Our ref: SO/2022/121848/03-L01
Your ref: Edwin Mawdesly
Date: 16 February 2022

A57 LINK ROAD (PREVIOUSLY KNOW AS TRANS PENNINE UPGRADE PROGRAMME) – DEADLINE 4 (16 FEBRUARY2022)

REP3-005 and REP3-024 – Flood Risk

FIGURE 13.2
GROUNDWATER RECEPTORS

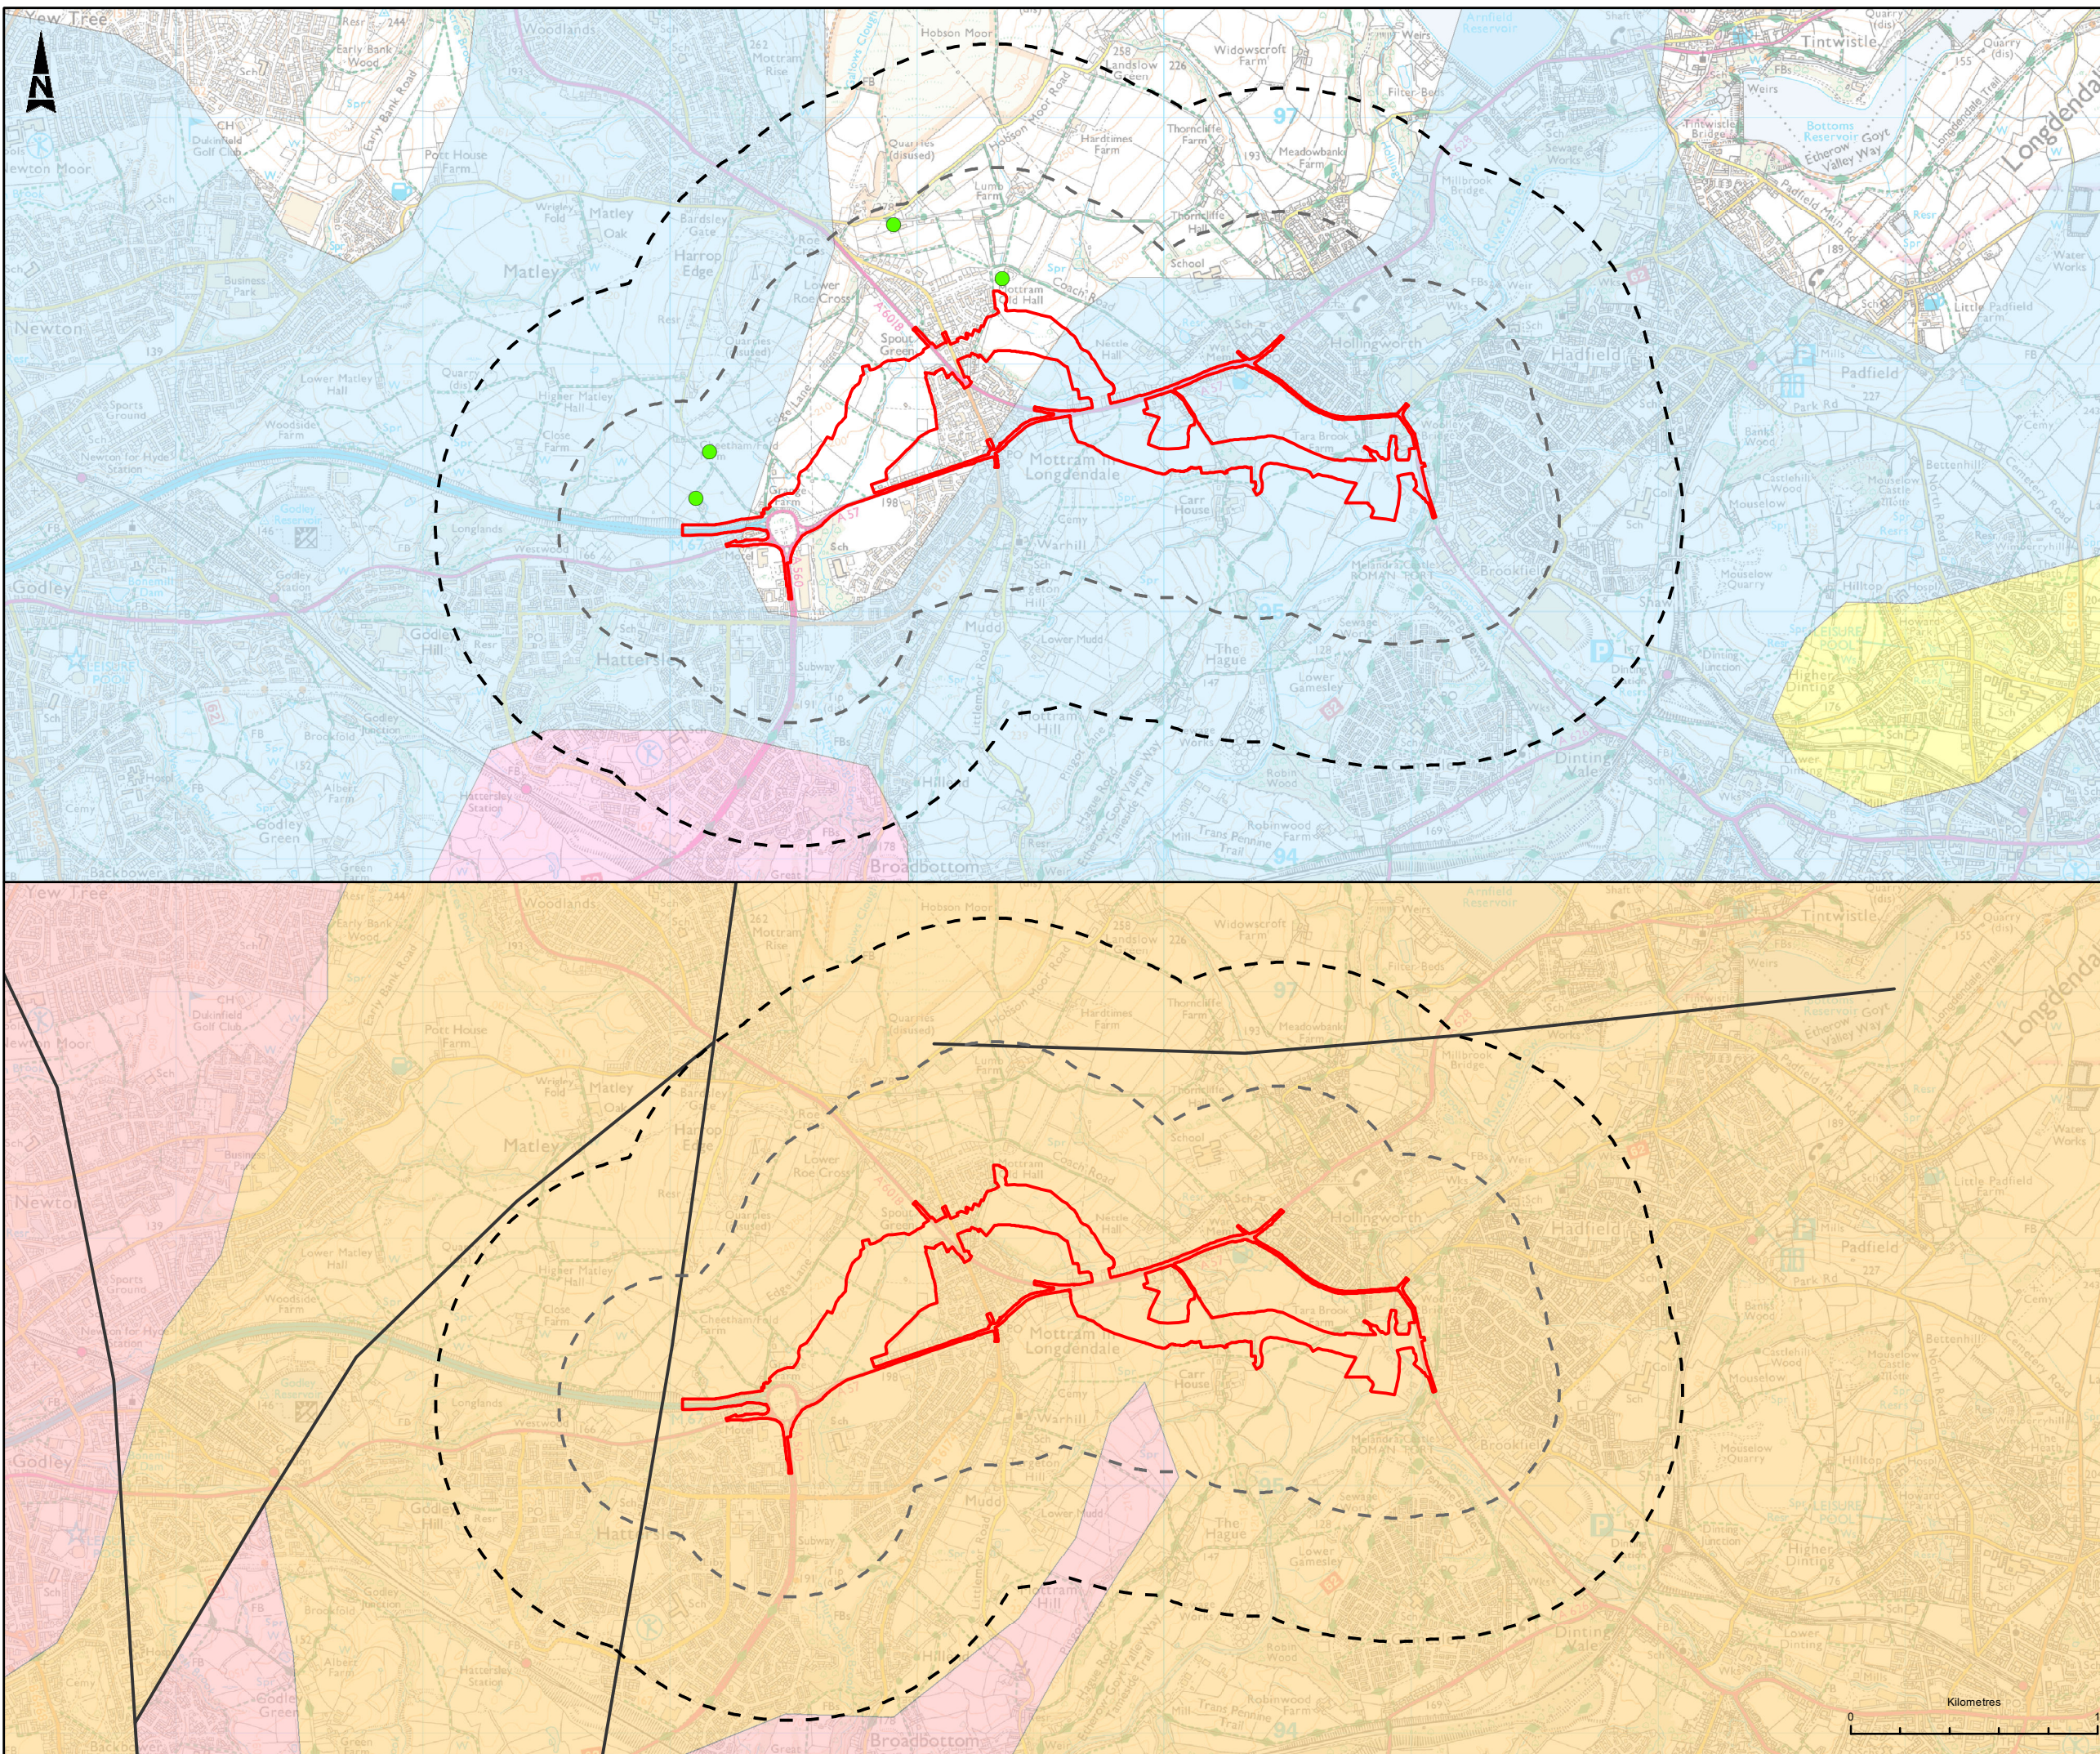
The Environment Agency have concerns, which have been raised with the Applicant previously, regarding the dewatering of the below ground level structures (cutting, underpasses etc.) in some locations could artificially dewater natural aquifer body.

These groundwater bodies are known to provide sole supplies of water (from an abstraction borehole) to several private dwellings. Dewatering of the aquifer would therefore deprive the owners and abstractors of these boreholes of water.

We requested a survey of water features in the area (as detailed in email exchanges from (WJ Group – Environment Agency April -July 2021) [which would have included identification of abstraction boreholes; springs, wells, and other relevant boreholes; surface watercourses and other water features such as ponds, lakes, and reservoirs] but to date we don't appear to have received any of these details.

Drawing Title
FIGURE 13.4 FLOOD ZONES

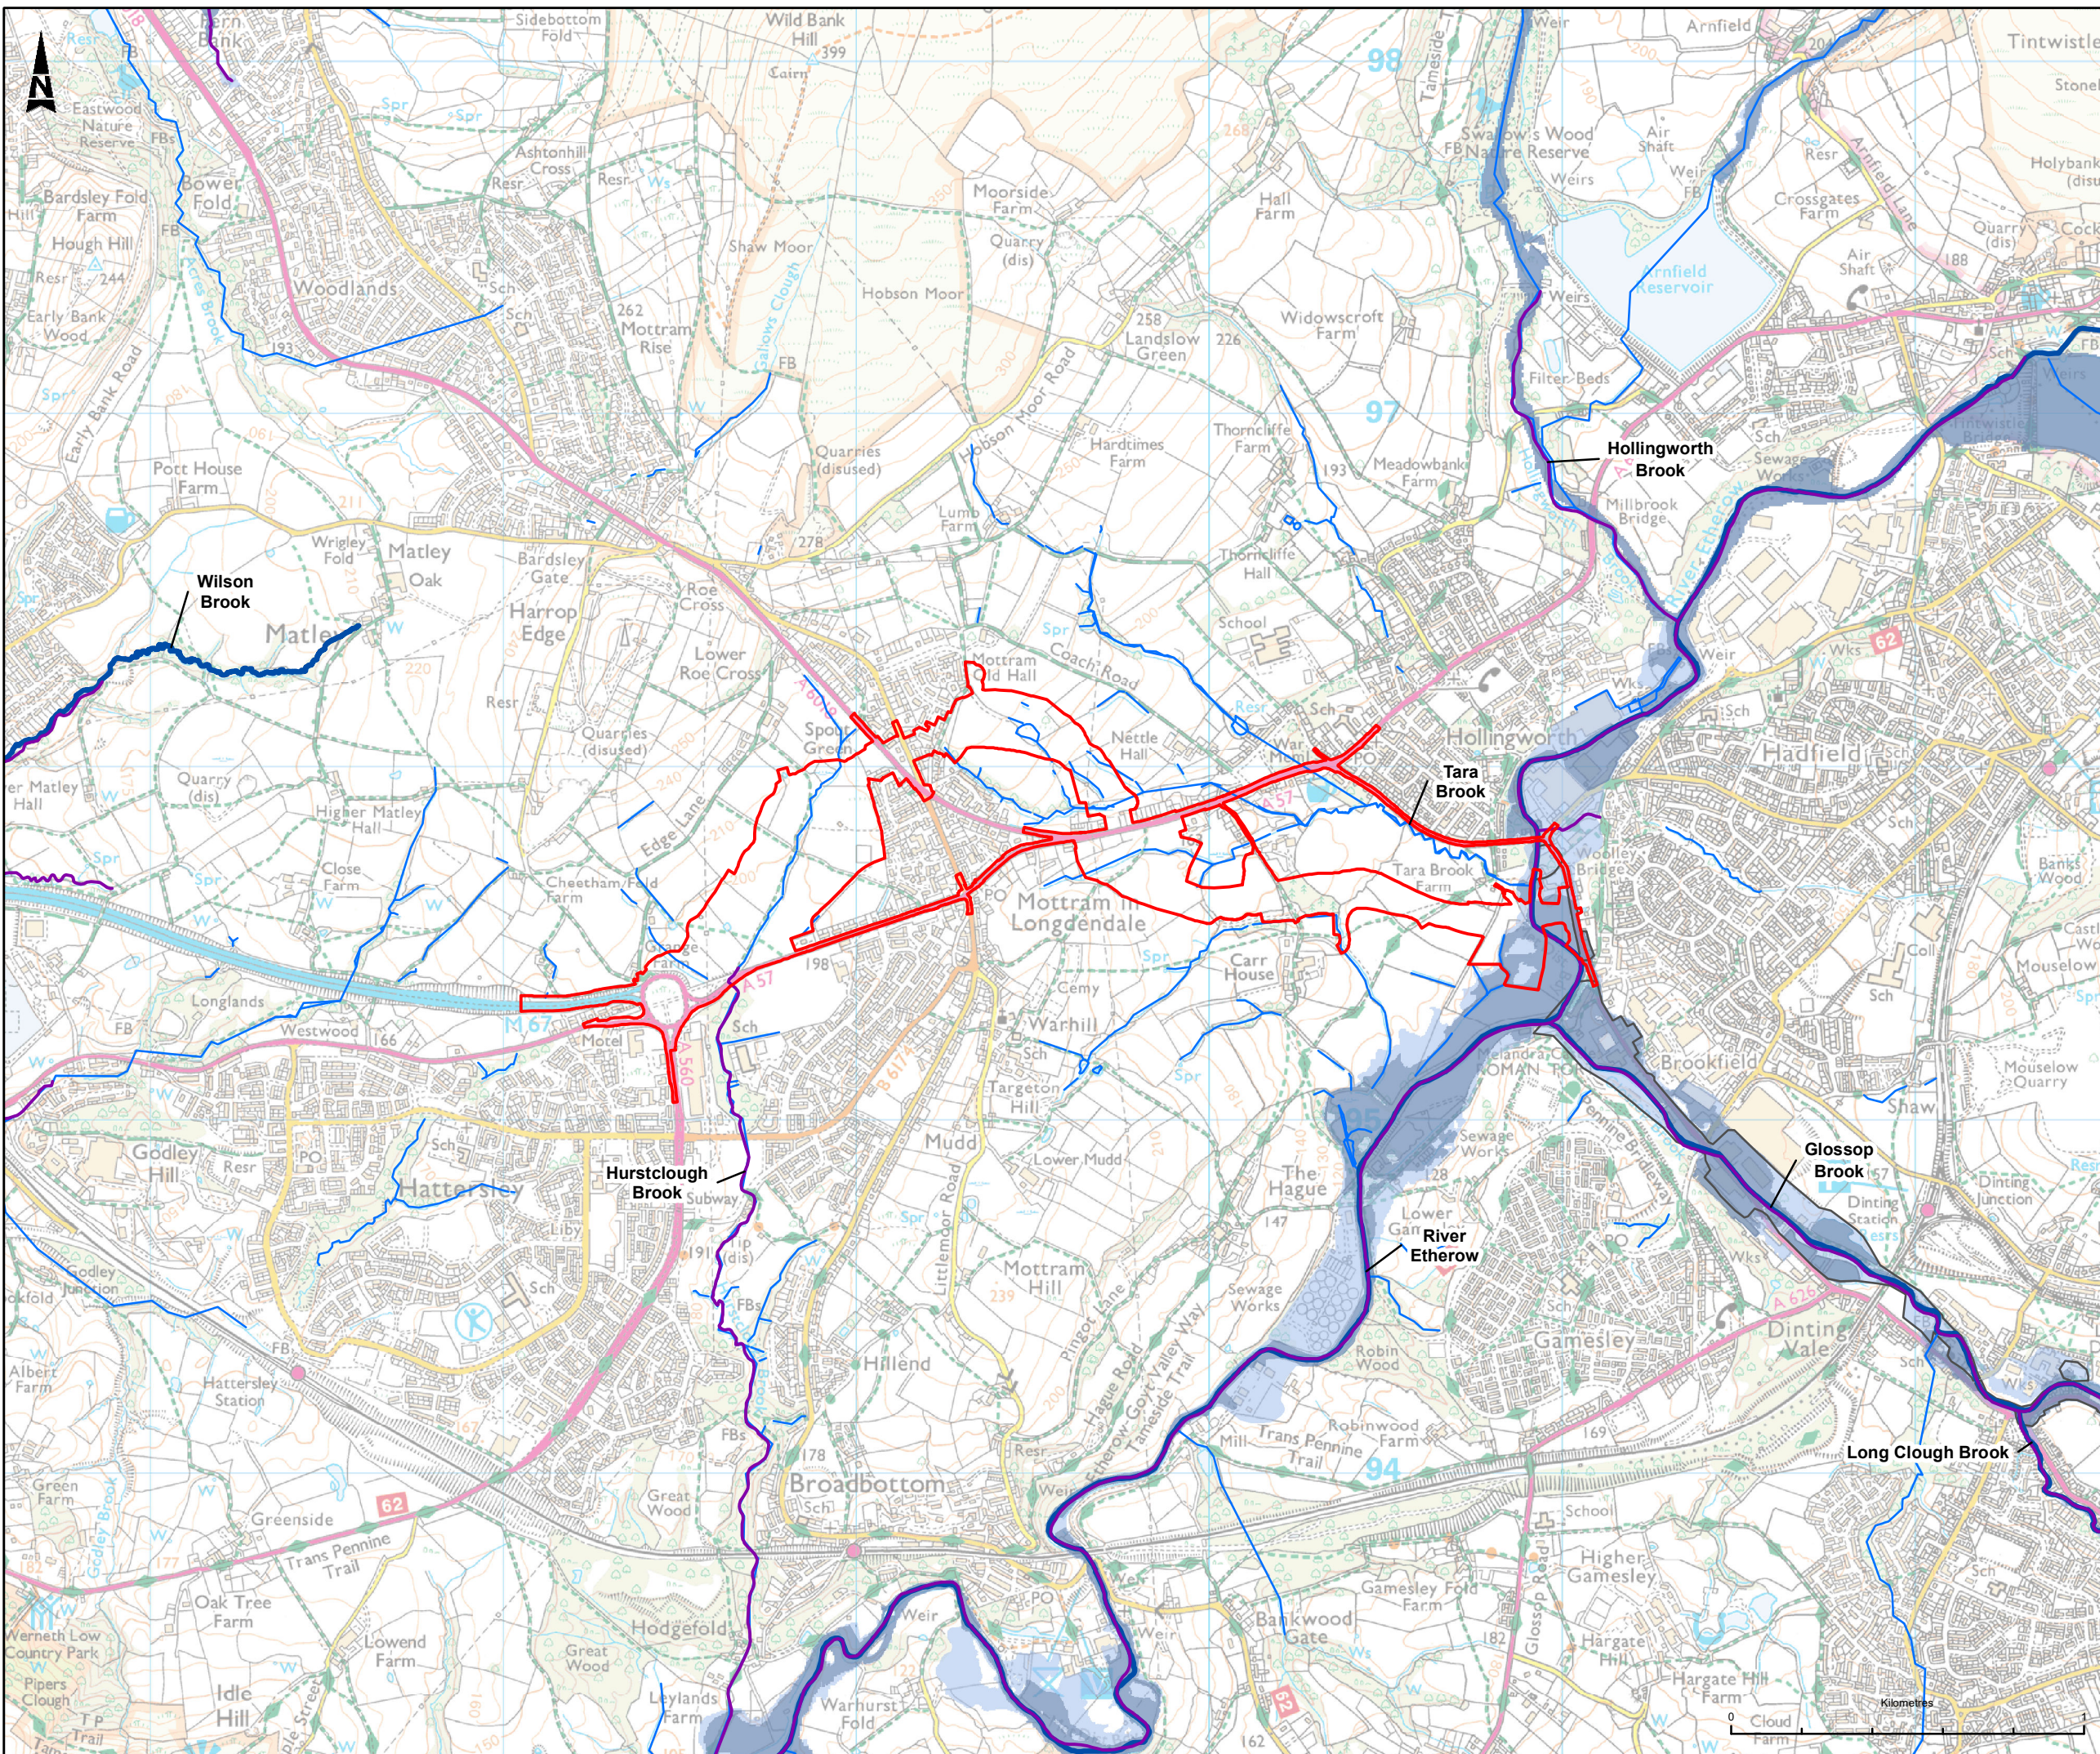
The FRA has not been updated to reflect the latest fluvial climate change allowances that were introduced in July 2021. We acknowledge that a considerable amount of design work was undertaken by the applicant prior to the July 2021 update, and it is unfortunate that the updated guidance was introduced soon after the first draft of the FRA was made. The compensatory flood plain storage within the FRA is based on 1% AEP 35% climate change allowance which was consistent with the guidance prior to July 2021. The revised guidance for the Upper Mersey management catchment suggests at least 41% should be considered for compensatory floodplain storage and 53% if essential infrastructure is present in the area affected. We have advised that the river modelling that informs the risk assessment for the proposed crossing of the River Etherow and associated flood plain compensation be reviewed.

The river modelling undertaken for the River Etherow crossing is discussed in section 4.6 of the FRA. Our river modelling specialists within the Environment Agency's evidence and risk team have reviewed the applicant's model on two occasions in the past. The most recent review was in March 2020. Although the applicant had made some progress at that time to produce an agreeable model to use in the risk assessment, there were some remaining questions regarding the detail of the river model constructed. These were raised with the applicant in March 2020 and again in November 2021. To date we have received no further updates to the flood risk modelling since our last discussions with the applicant in a meeting on 25th November 2021. It is not clear at this time whether the applicant intends to address these points we have raised previously. We believe these detail issues in relation to the river modelling for the River Etherow should be addressed to ensure a robust assessment of flood risk. However, we would point out that requesting our river modellers to undertake a detailed river modelling review normally takes approx. 4 weeks.
